DRB Minutes, Agenda Items 6 & 7
August 11, 2021

DESIGN REVIEW BOARD

Agenda Item 6
Project Number PR-2020-004595
Applications:
SD-2021-00111 - Preliminary Plat
VA-2021-00216- Sidewalk Waiver

Agenda Item 7
Project Number PR-2020-004595
Applications:
SD-2021-00122 - Vacation of Public Easement (7')
SD-2021-00123 - Vacation of Private Easement (15')
SD-2021-00124 - Vacation of Private Easement (20')

# Tree Survey

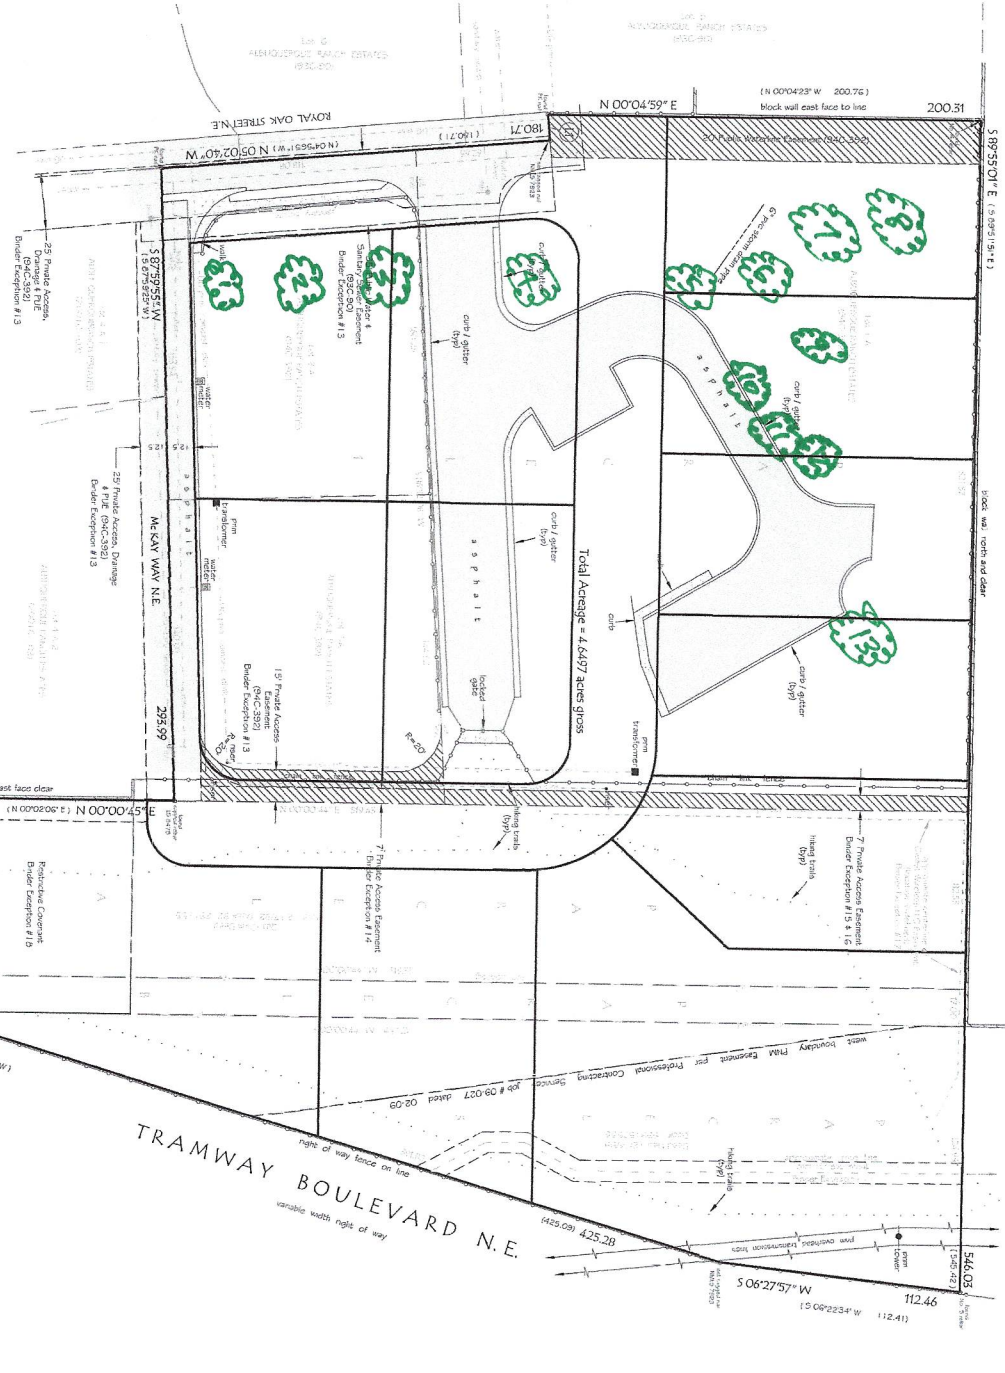
And there -- so originally, the applicant showed 13 trees on the tree survey, and that would then trigger the IDO requirement. The -- unfortunately, the IDO isn't very clear about then if after the trees are analyzed and you become then less than five, which is the IDO requirement, if that then, you know, still requires those trees to be retained, if it's then less than five, which is then less than the large stand of existing trees -- because it could be interpreted that, you know, the large -- more than five trees triggers the city forester visit, and then the city forester makes a report. And then after that -- or determination or evaluation, and then after that, it's not exactly clear what -- what would happen.

So I -- I'm looking at these historic photos and it does appear that those trees at the entrance, which were still in decent condition and originally planted with the original residents, are old enough. And whether or not they meet the 16-inch at breast height, the -- definitely that first one does. That's kind of also difficult -- you know, it's not an exact science of exactly how to measure, because there's many branches, you know. So we're kind of just giving a -- an estimate.

So our feeling is that those three trees could be saved, but obviously the first one is in the best condition. So because there's still not complete clarity on how to go forward, my question is, do you think that that first tree would be able to be saved with this project?

MS. GARCIA: Okay. Thank you. Madam Chair, you know -- but after further review of the -- of the trees and measuring the diameter of the trees, based on the 2019, those three trees that are near the entry, only two of those trees met that standard, not all three.

And so the first two from the south were identified to have met that definition. The diameter was more than 16 inches. However, the -- it's also our understanding that the -- the representative from parks did not -- did not mention that those trees should remain.

But the applicant -- or the comments that have come in indicated that all three of them should -- should remain, even though the one furthest north did not meet that criteria, all three of them should remain. But that is the area that is -- could be problematic to maintain, because there is going to be some grading work done in that area that could affect the trees. You know, there is quite a bit of a slope there, and if we have to build up that -- that grade, it could really bury that -- bury that tree.

MR. FIERRO: Okay. So I walked the site, and based on the elevations of the finished pads, and where the trees are located currently, they're kind of, like, in a low area. And so when I was doing the grading plan, I want to keep the pad above the road, at least at top of curb. So that will require some filling where those trees are currently.

Also, the road's going to be built up maybe -- or the house pad's going to be about two feet or three feet higher, and there's going to be some grading in that work, where -- oh, I think it would pressure on the trees, just from the fill of the pad and the lot.

MR. FIERRO: The grading plan, I -- I do not think so. Because my grading plan was kind of putting some fill there, and going from the back of curb up to -- up to the house pads. And I -- I don't think -- if we do fill it, I don't think there's a good chance of that tree surviving, even if it stays.

**NEW EASEMENTS:**

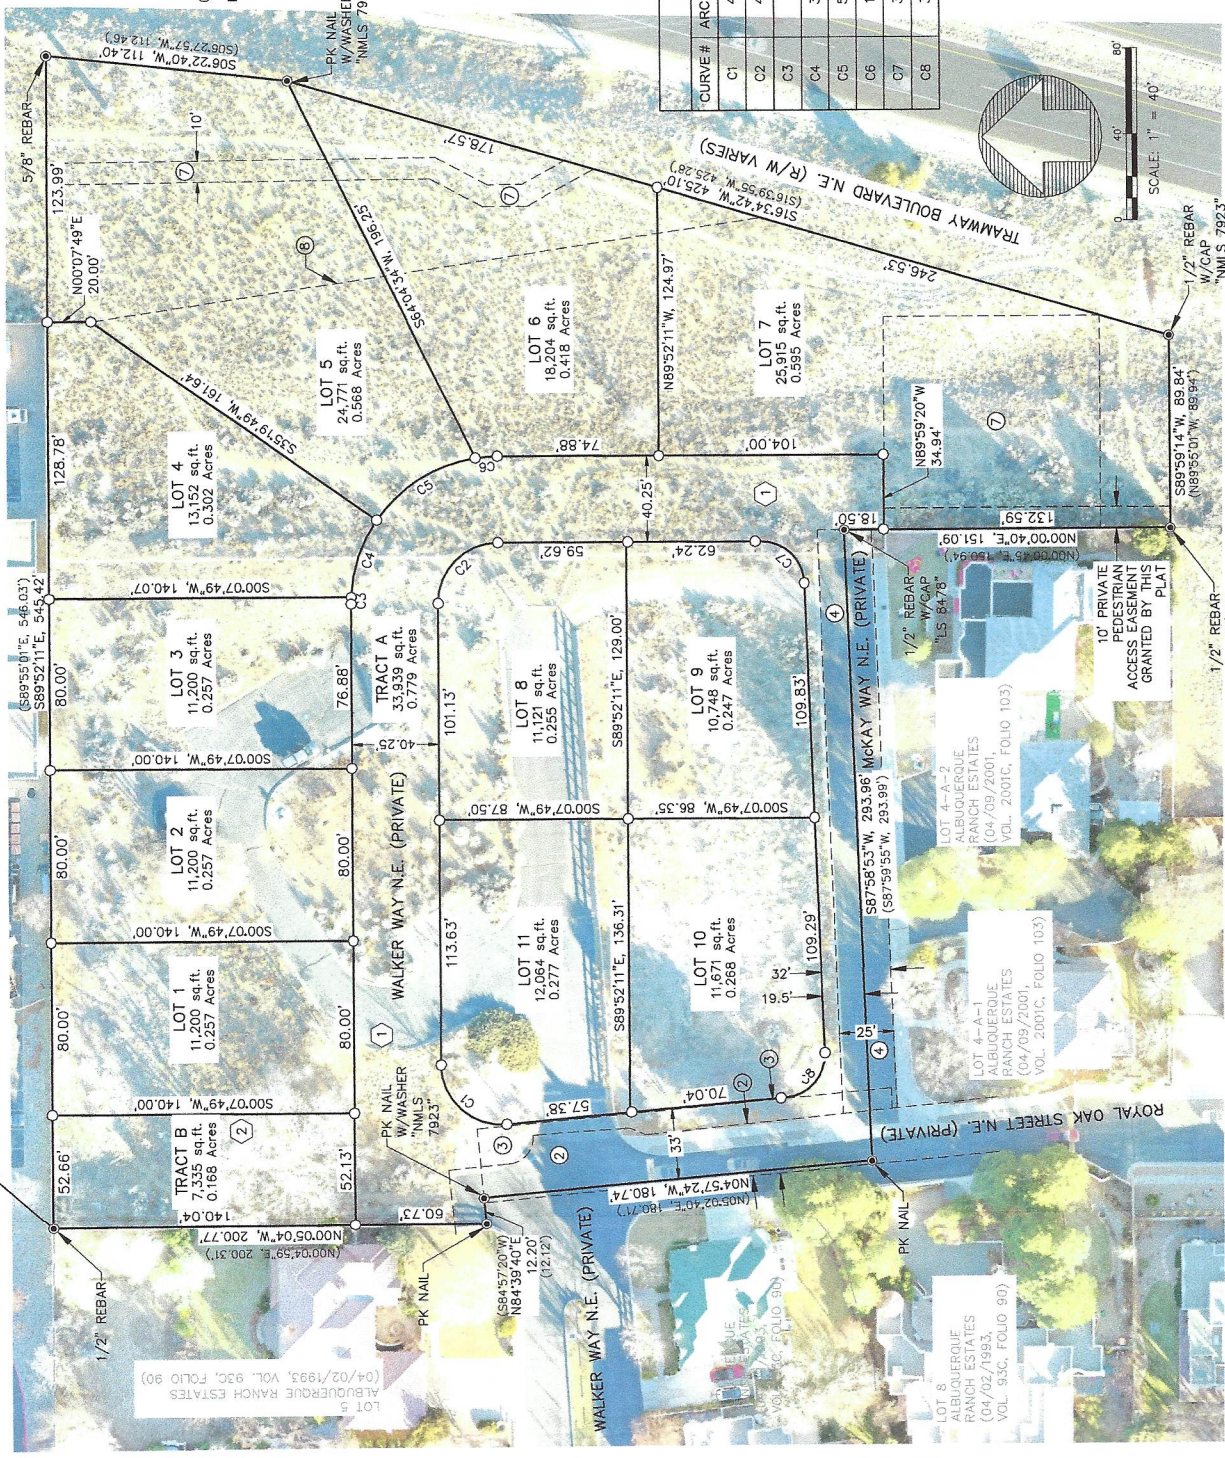
MR. CARTER: Thank you, Madam Chair. This is Blaine Carter for the water authority. Our previous comments have been resolved. There's one I'd just like to confirm. We -- I (inaudible) in terms of the latest drawing. There's a note, and I believe it's on the right side of Jay's screen there, under new easements. We just need to confirm that the HOA and road tract does include a public water and public sewer easement in one of those notes. And if that's the case, I think we're good to go (inaudible) there.

I think it doesn't affect the trees (inaudible) PUE. It's just that note I misread. It actually -- there's other language that needs to be added to that note. I want to make sure we have that in the plat that's going out for signature.

So it's not related to this current discussion, but related to our prior comment. We need that resolved prior to our signature. It needs to include a public water and public sewer easement on that Note 1 for a document that was sent to resolve the comment. So it's easement Number 1 on that Sheet 3 before we sign.
